M25 Junction 10/A3 Wisley Interchange Improvement Plan

I enclose written representations on behalf of the Guide Association Trust Corporation and Girlguiding Greater London West ("GGLW").

Written representations on behalf of the Girl Guiding Greater London West and Guide Association Trust Corporation

Appendix 1: Indicative plans discussed at meetings on 24 February 2020

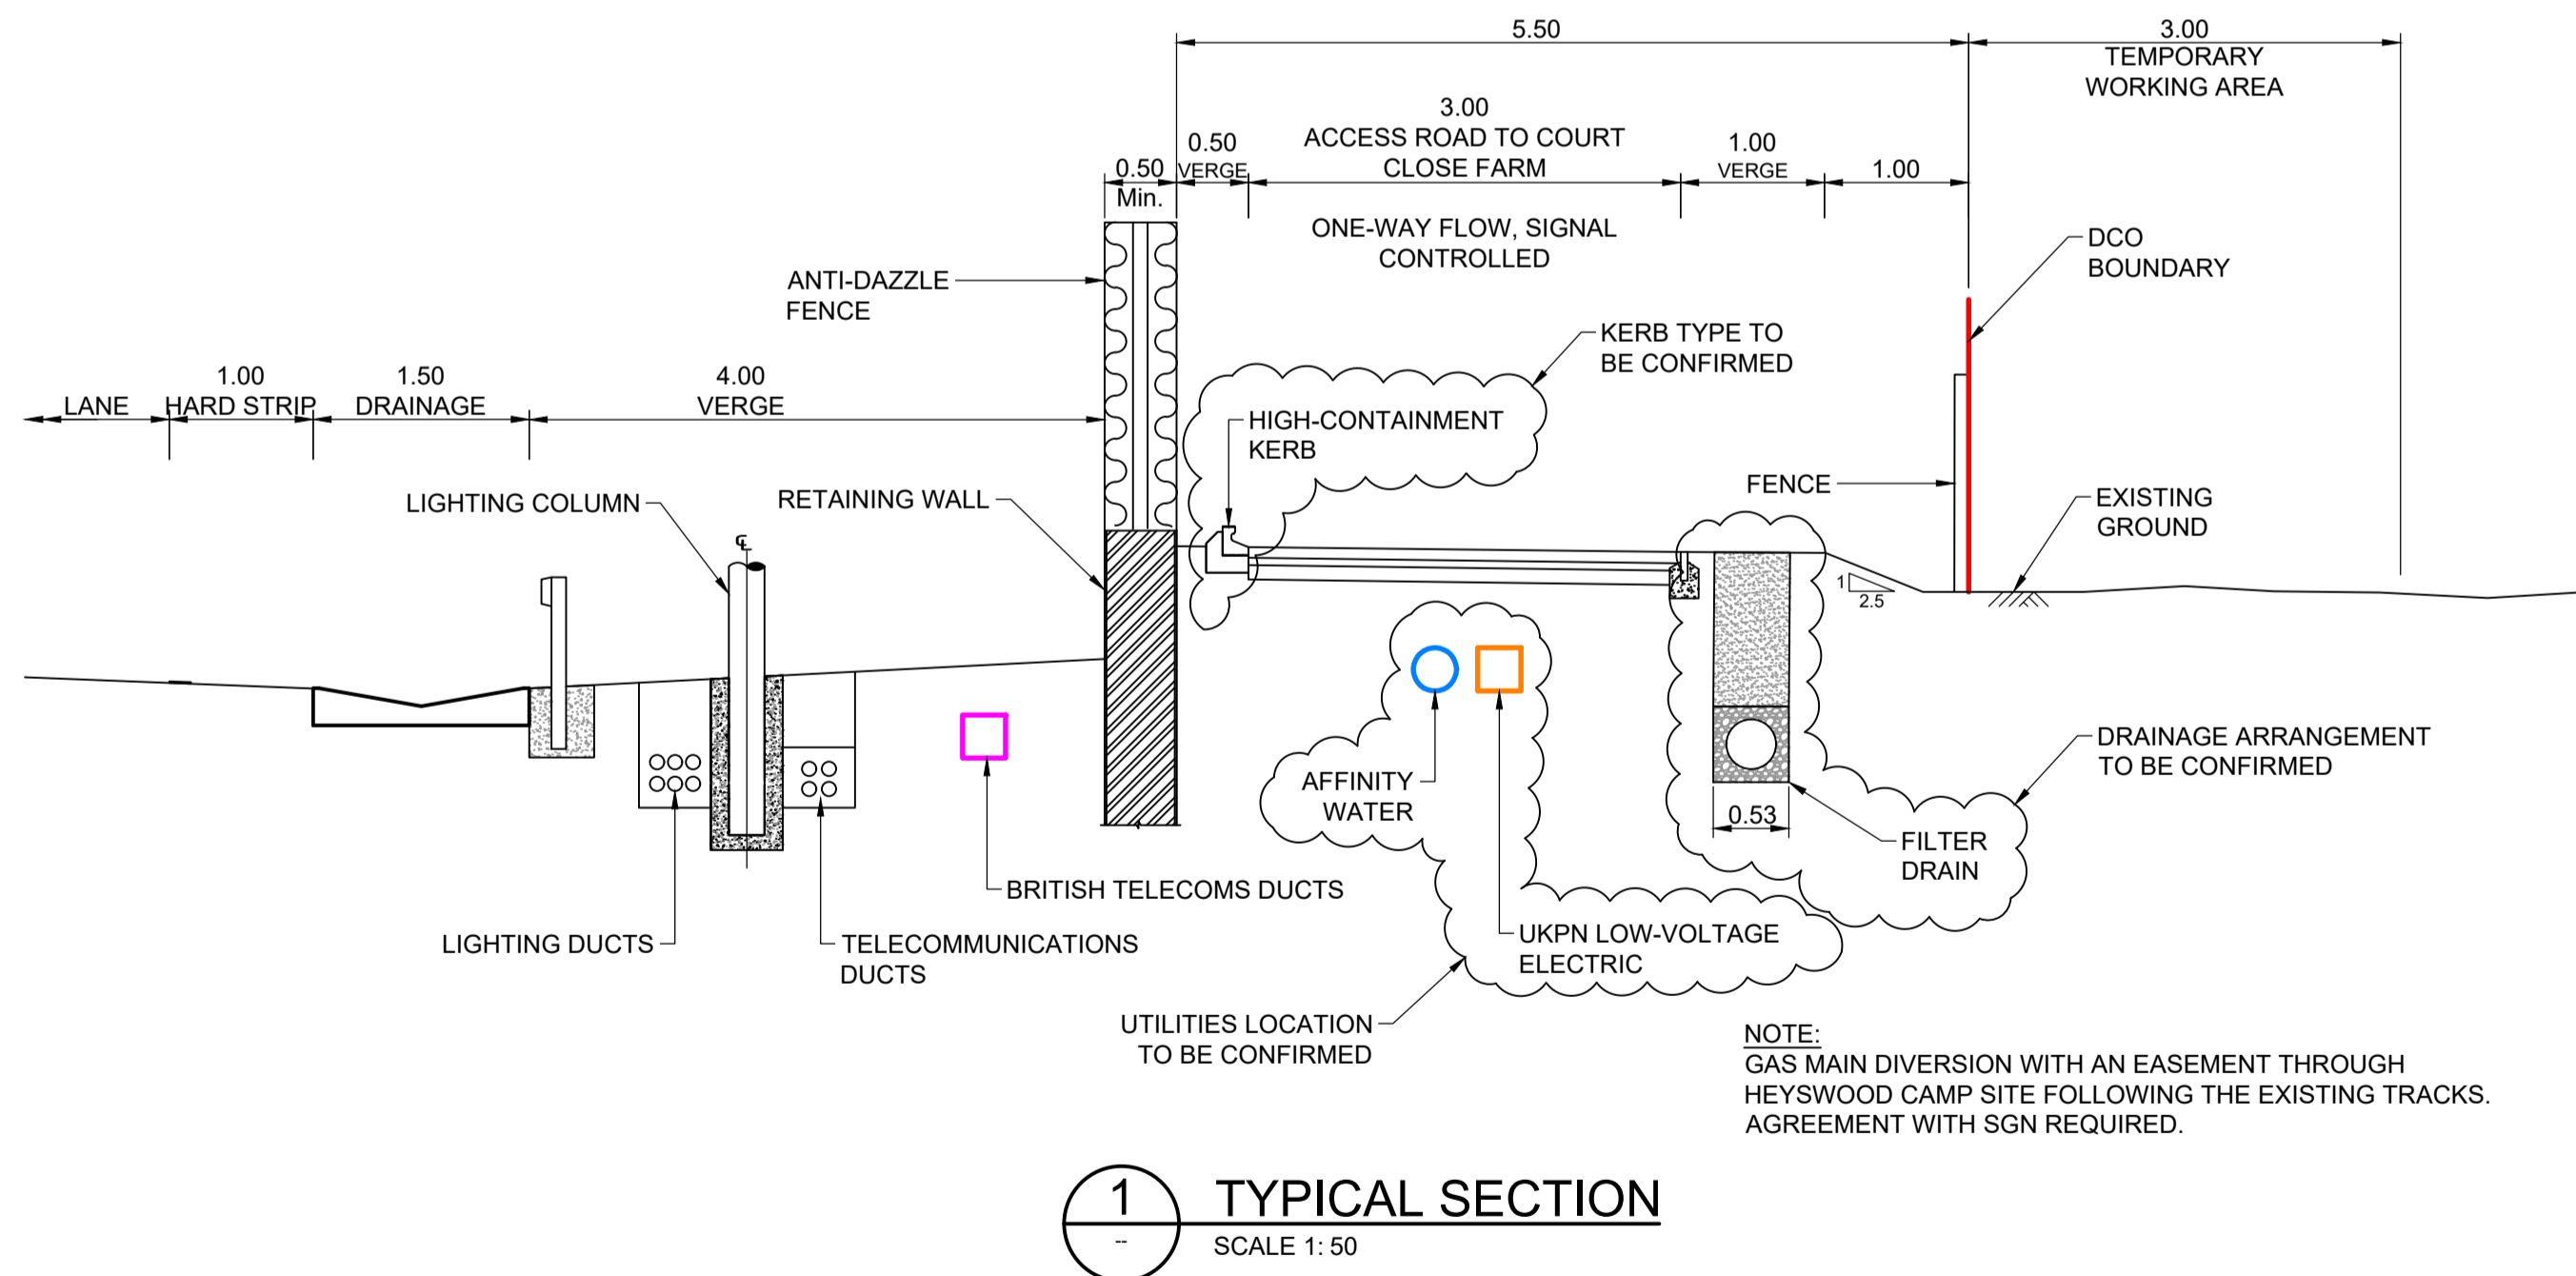
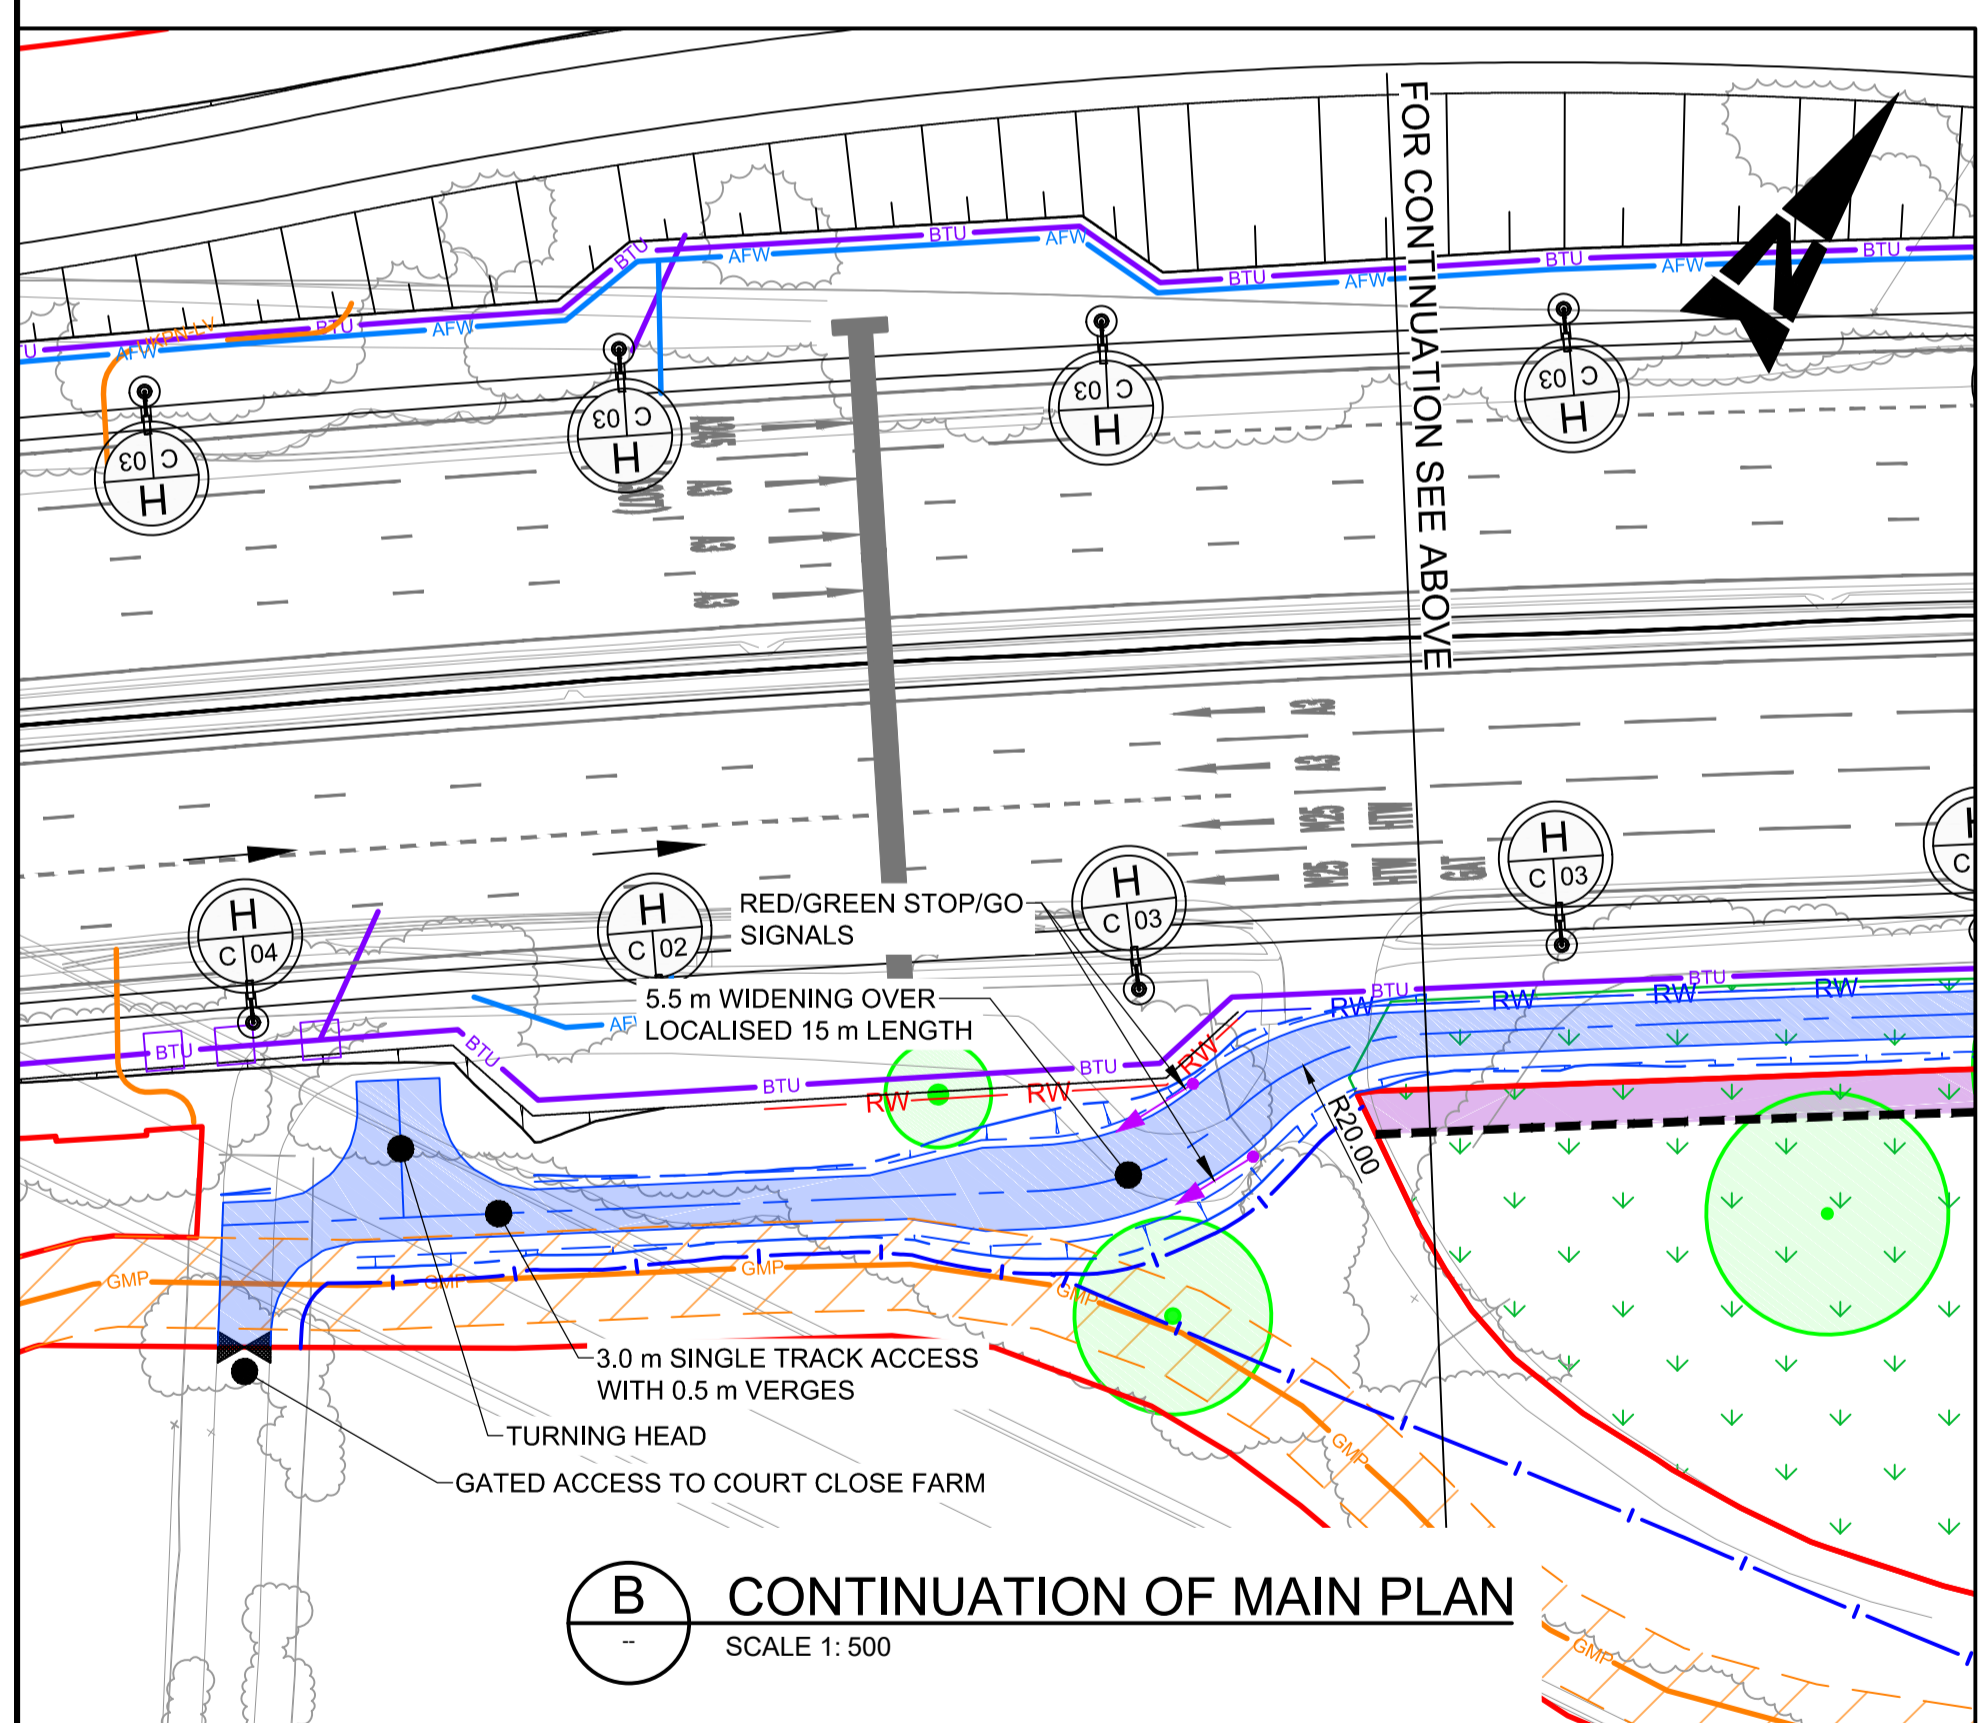
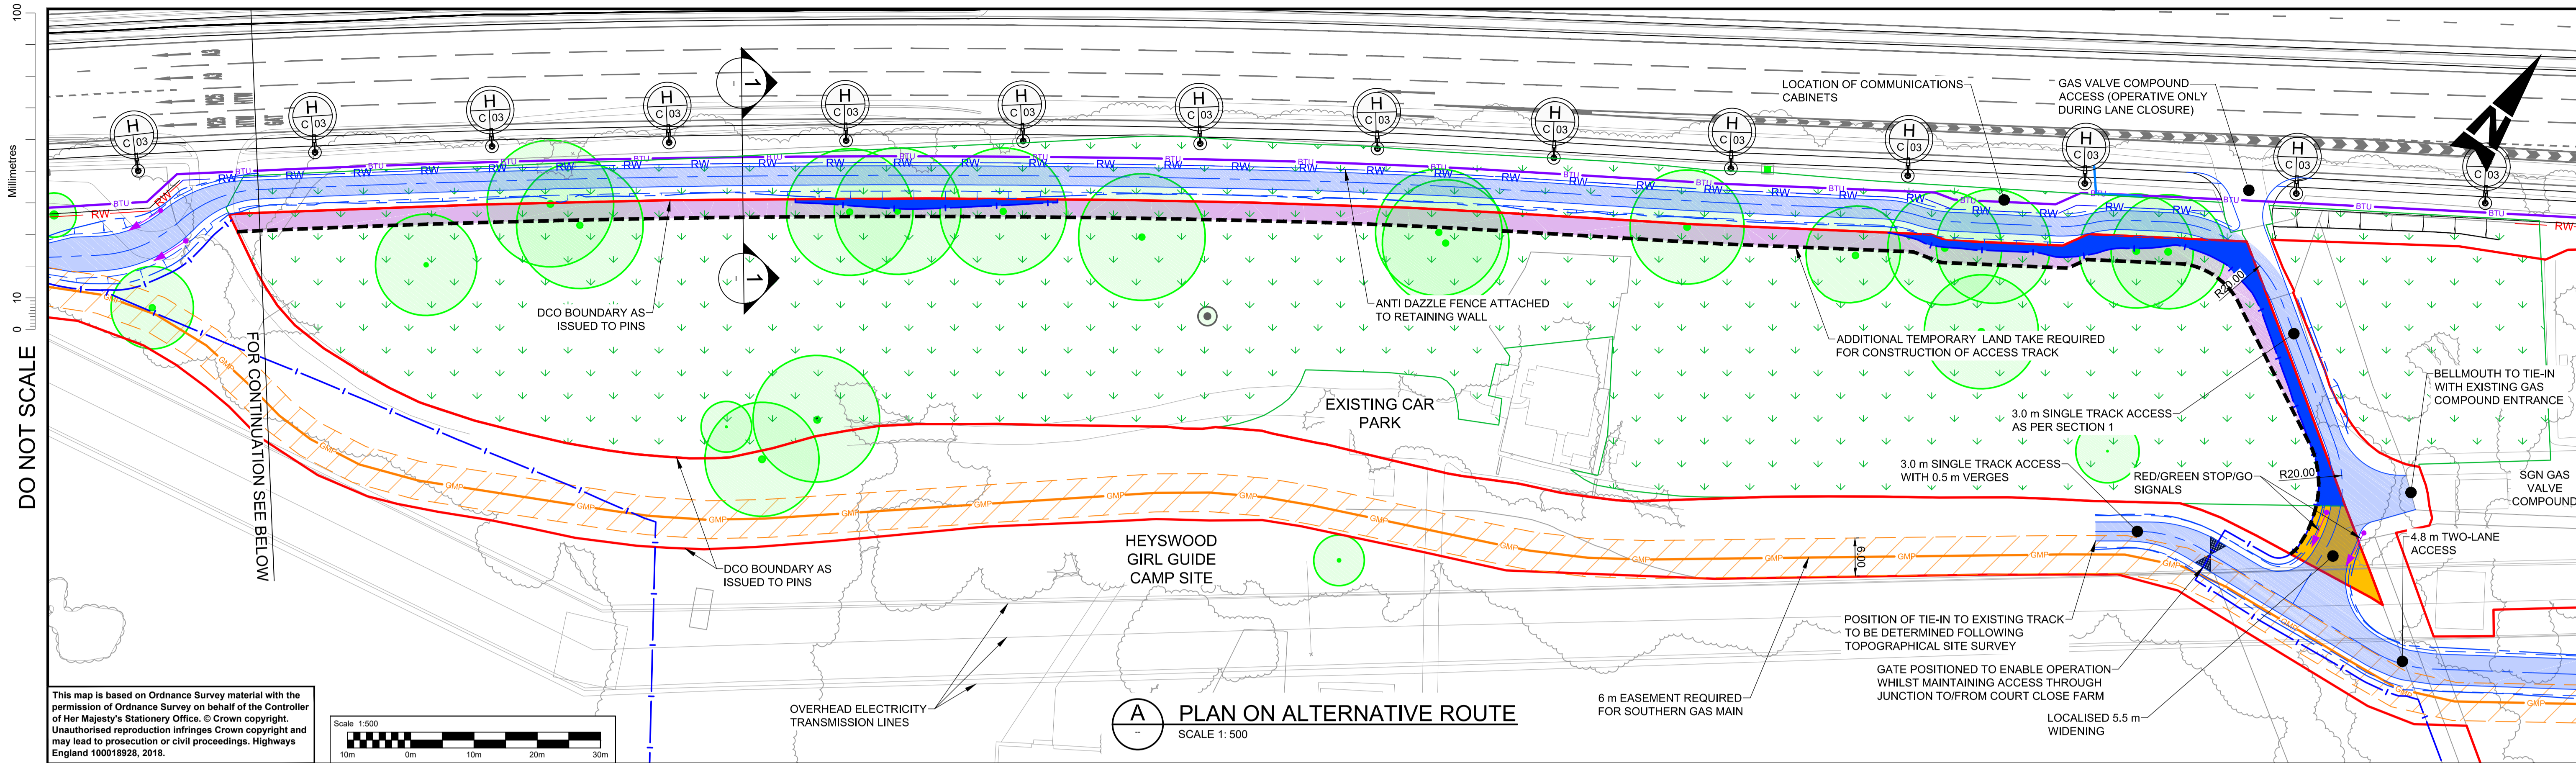
- (1) that the current proposed access is flawed and should not be consented; and
 - (2) that a far better alternative would be to locate the new access route further to the north (“the GGLW Alternative”), so that it can run along the edge of the widened A3.

3. In these circumstances, GGLW asks the ExA to require the Developer to explain its reasons for not selecting the GGLW Alternative (which was discussed with the Developer at 2018) and submits that the DCO is flawed and should not be consented in its current form.

10. The alternative which GGLW have previously discussed with the Developer would be to relocate the access road closer further to the north, so that it runs alongside the widened A3. This would:

- Minimise the necessary land take from GGLW;
 - Avoid the “sterilisation” of any additional portion of the Campsite by subdivision;
 - Facilitate the provision of security measures; and

- Reduce the environmental impacts of the access road.
11. Although the Developer’s reasons for not adopting the GGLW alternative have never been properly explained to GGLW, it is believed that the core reason is that further land take next to the A3 southbound lane would result in additional loss of Ancient Woodland.
